Application number: SSD-9483

### **Letter of objection to the proposed development of Chatswood Public School (CPS)**

Thank you for the opportunity to review the plans for the development of the Chatswood Education Precinct. We have many serious concerns about the process undertaken and the plans presented in relation to the Chatswood Public School (CPS) site. These are detailed as follows.

2 Elevation West P1
SCALE: 1 : 250

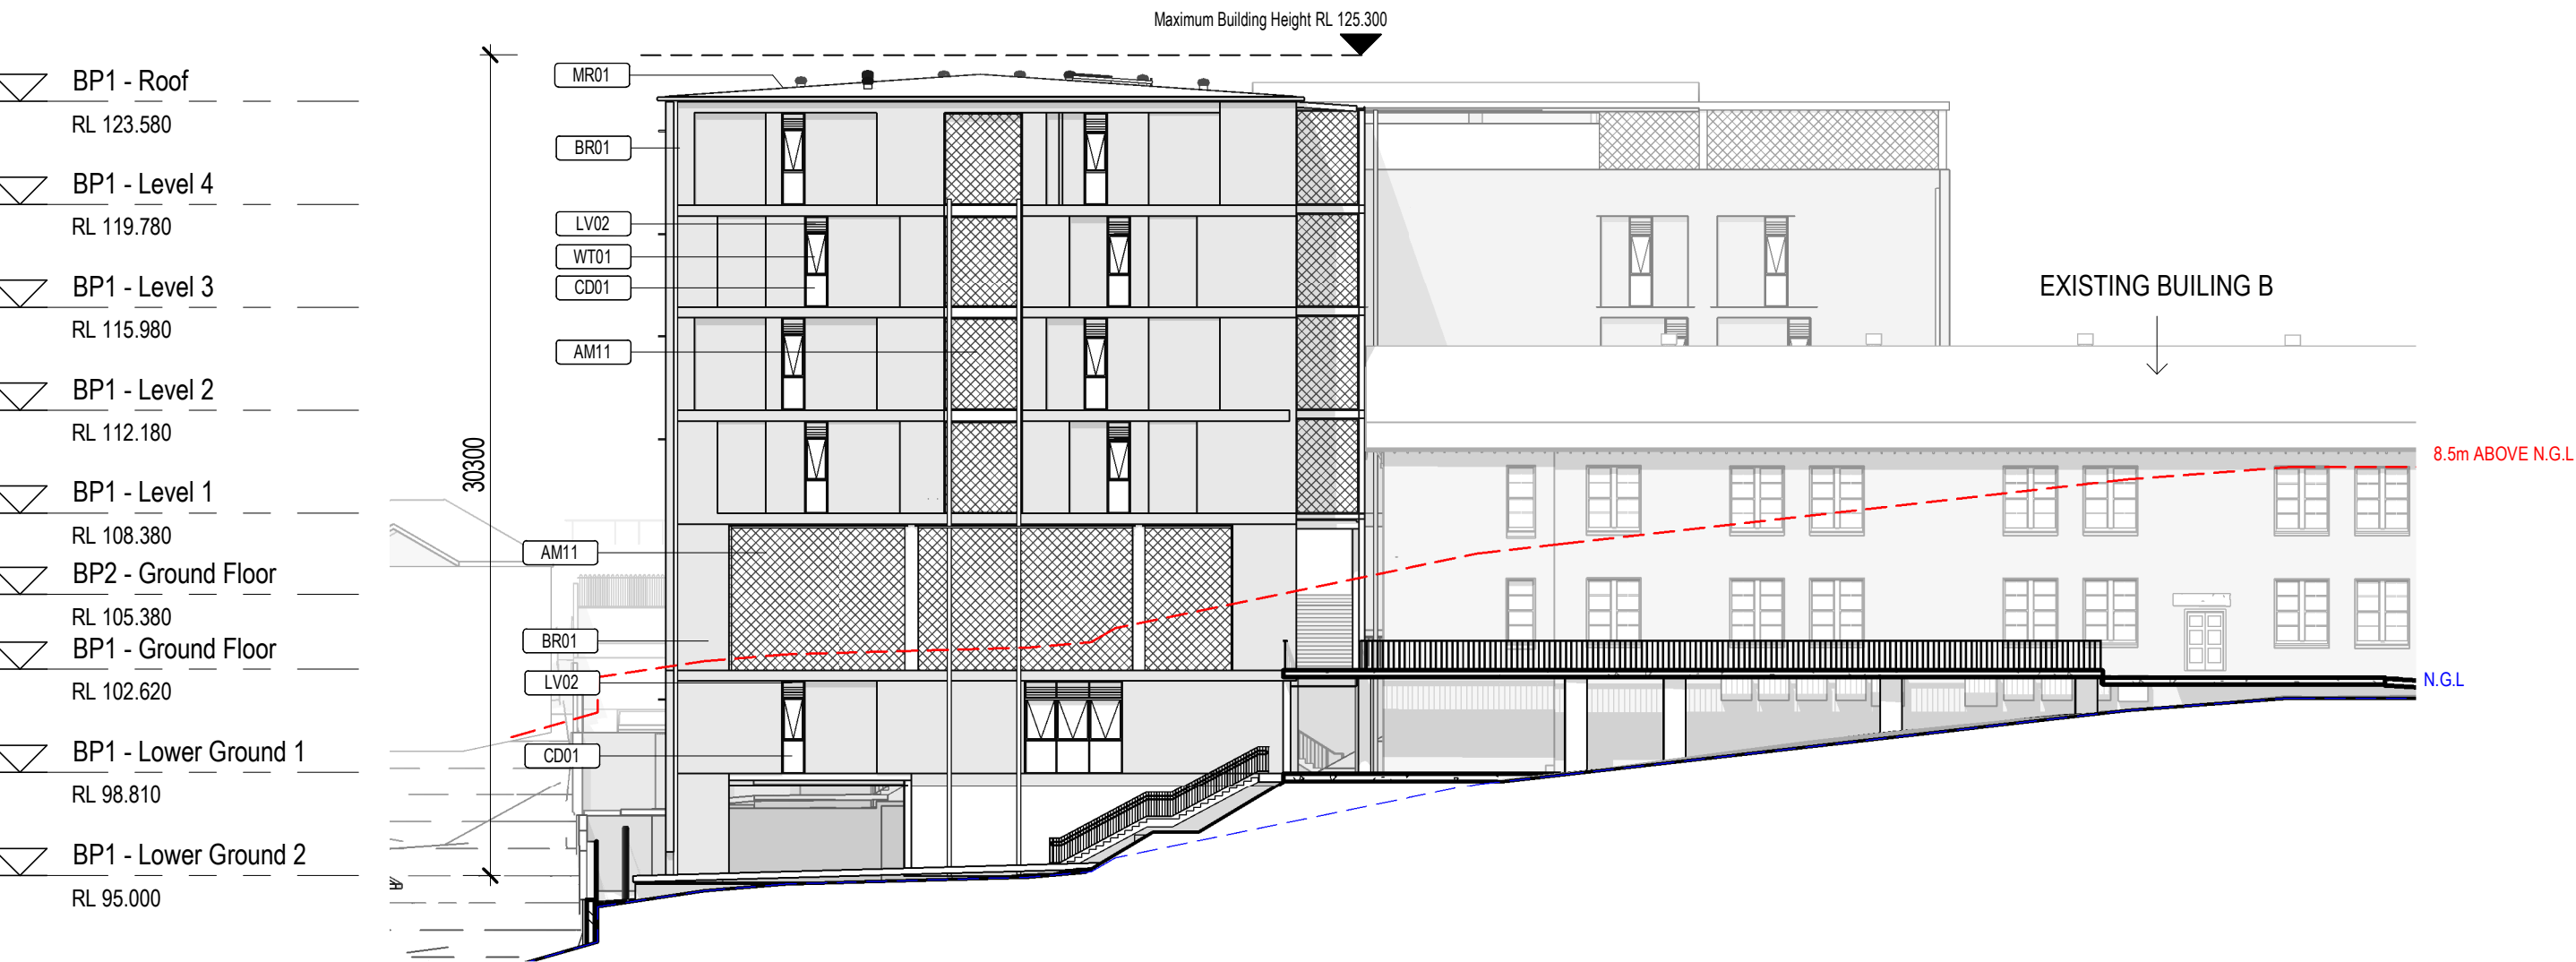
Furthermore, in a meeting on 29 April with Alex from school infrastructure ([schoolinfrastructure@det.nsw.edu.au](mailto:schoolinfrastructure@det.nsw.edu.au)) and the project team, it was clarified with us that P1 is in fact a seven storey building despite it being referenced in many documents including the EIS p 21 as below as a six storey building.

While the seven storeys are evident in the Elevation West P1, until this meeting, we assumed that the EIS was correct based on our clearly misguided faith that a government agency would provide us with true and

3 Jenkins Street - Street Elevation
SCALE: 1 : 500

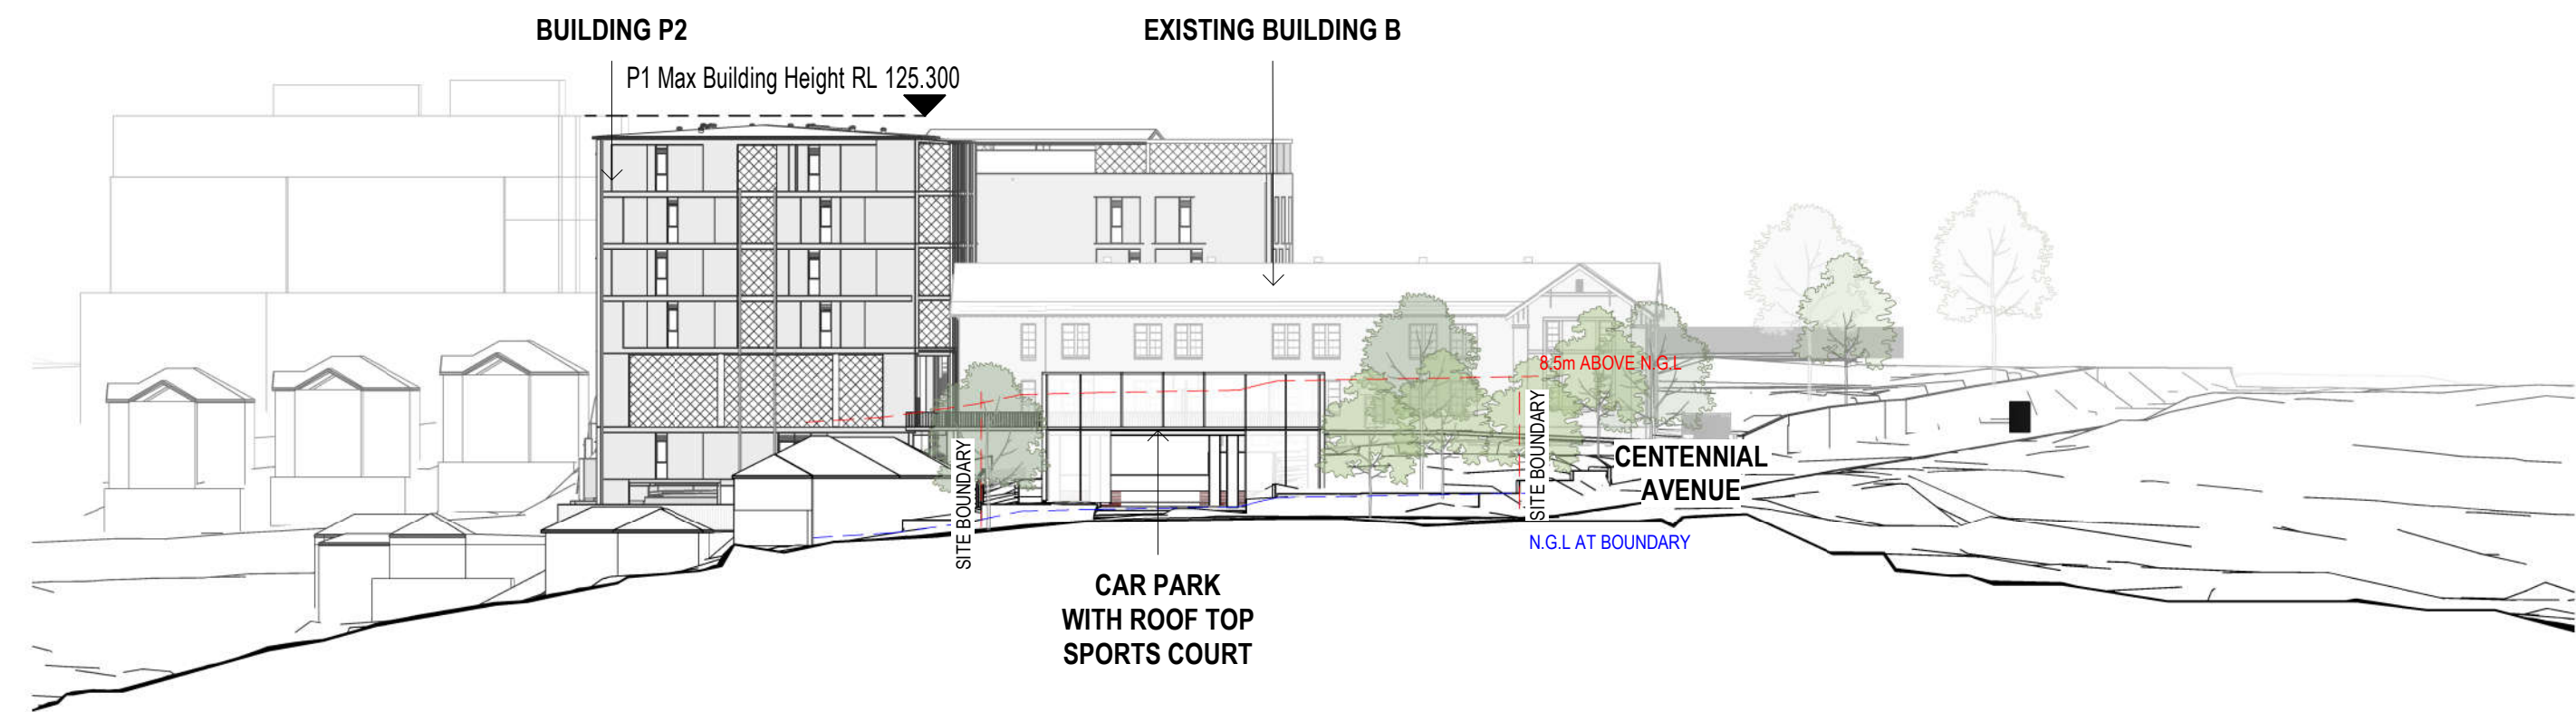
While this may be true of the eastern side this is not at all true of the western side. As is obvious from the Jenkins Street – Street Elevation, building P1 appears almost double the height of Building B and the mass, scale and visual bulk of P1 dwarfs this heritage building. There is no capacity for planting given the proximity of the planned building to the boundary and furthermore, no tree grows to six/seven storeys in height. We would like an explanation as to why the view from the Western side of the highway, as per Jenkins Street – Street Elevation, has not been considered.

Site Section Buildings P & G

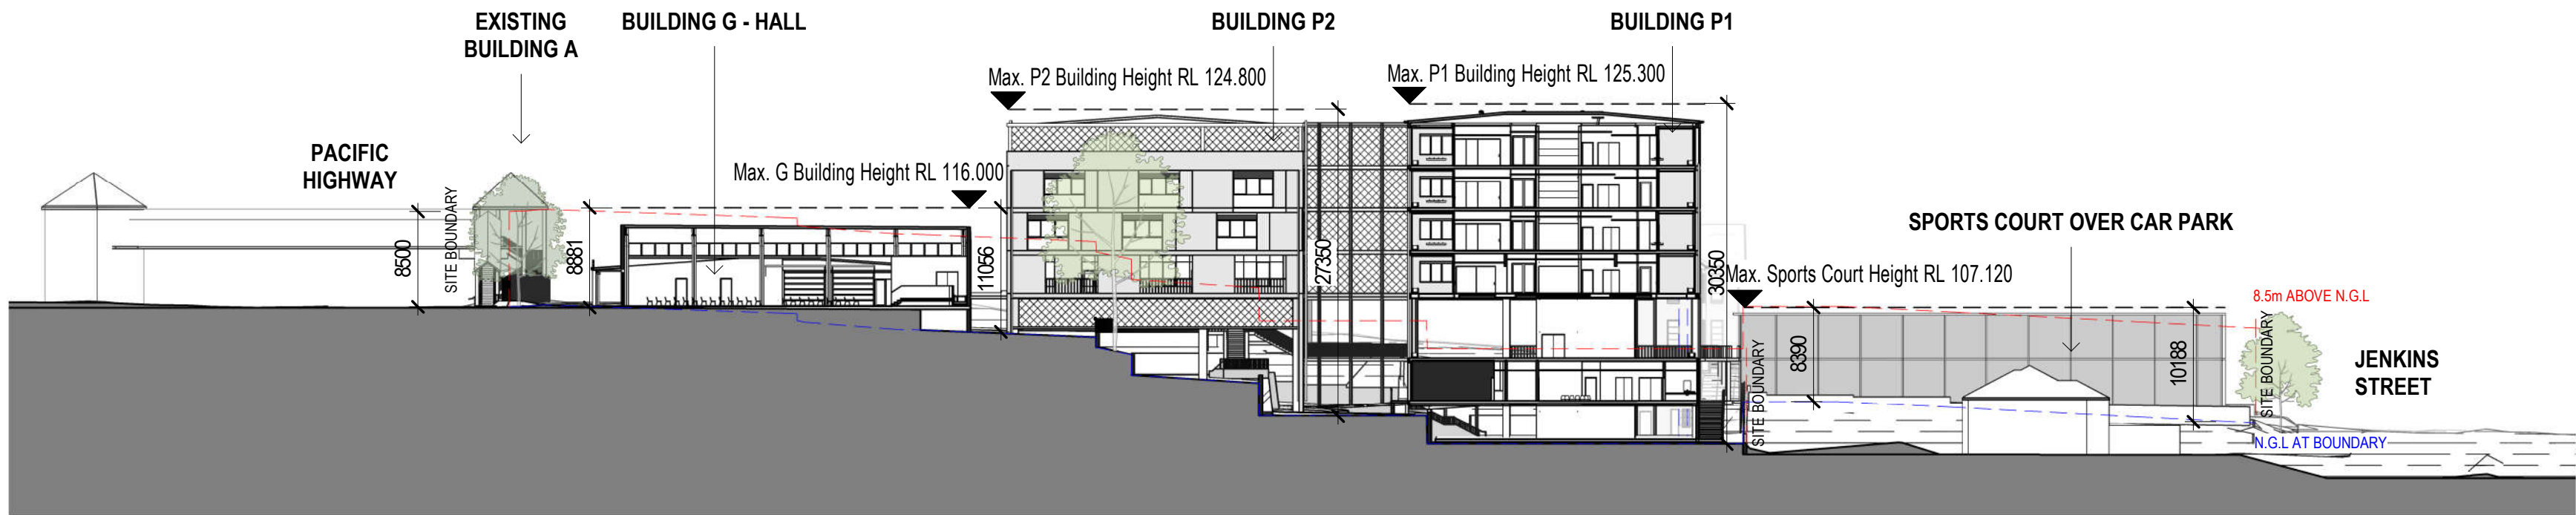
Furthermore, the following Site Section Buildings P&G clearly indicates the dominance of the proposed structure over local landscape, particularly 1 Jenkins Street, and reflects the inappropriate mass and scale of the development.
